A2 2000-2 Addison Road
FAA Notice - 2004

From: Luis Elguezabal [luis.elguezabal@wgint.com]
Sent: Wednesday, September 29, 2004 2:41 PM
To: Bruce.beard@faa.gov
Cc: Jim Pierce
Subject: ADS Runway 33 Threshold

ADDISON ROAD IMPROVEMENTS
BELT LINE ROAD TO ARAPAHO ROAD PHASE I
ADDISON ROAD LANDSCAPE/LIGHTING

DESIGNED BY: J.W.B.	PROJECT: 2002 102	SHEET NO. LS1
DRAWN BY: TJH	DATE: JUNE 2004	OF 58 SHEETS

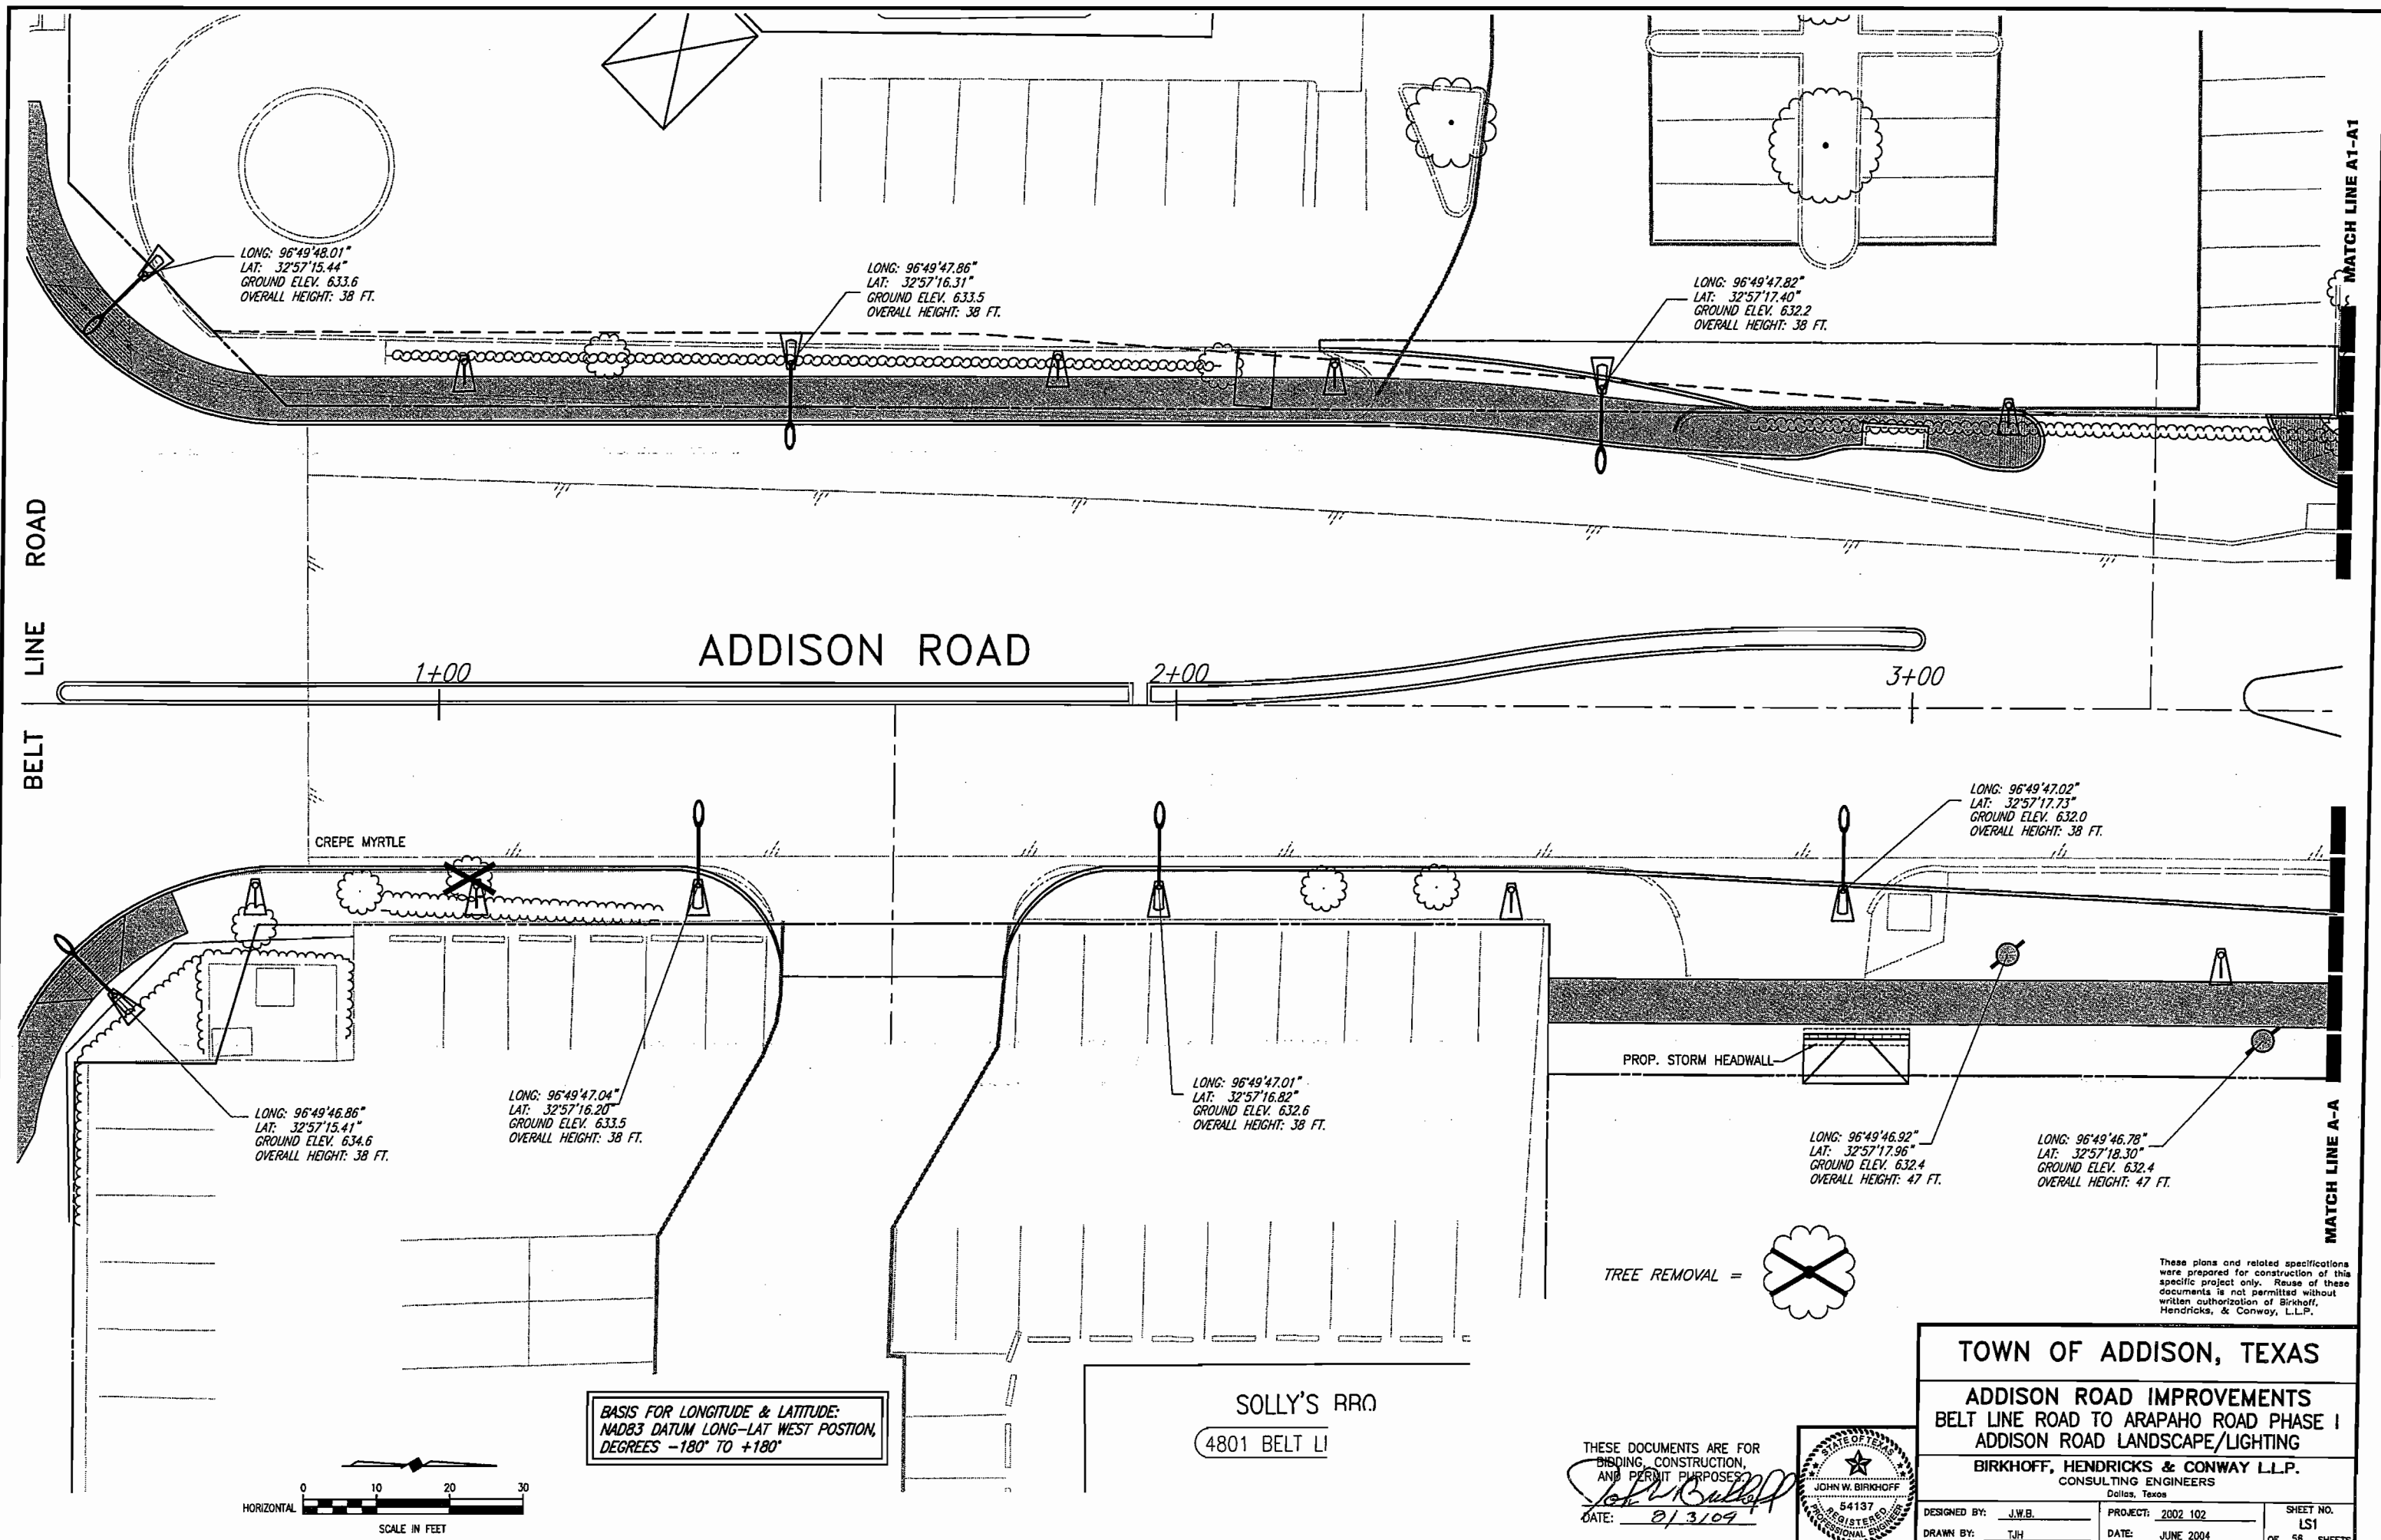
Per our recent conversation, Addison Airport Management does not have any plans to re-capture the 771 feet of displaced runway on the approach end of runway 33 due to the fact that: Lindbergh road, the railroad line, and the future Arapaho road do not allow for adequate clearances. (FAA requires seventeen feet of clearance over roads and twenty-three feet of clearance over rail lines.)

In addition, these obstacles will be in the safety area, if the displaced section is re-captured. It is cost prohibited to relocate or remove these three right of ways.
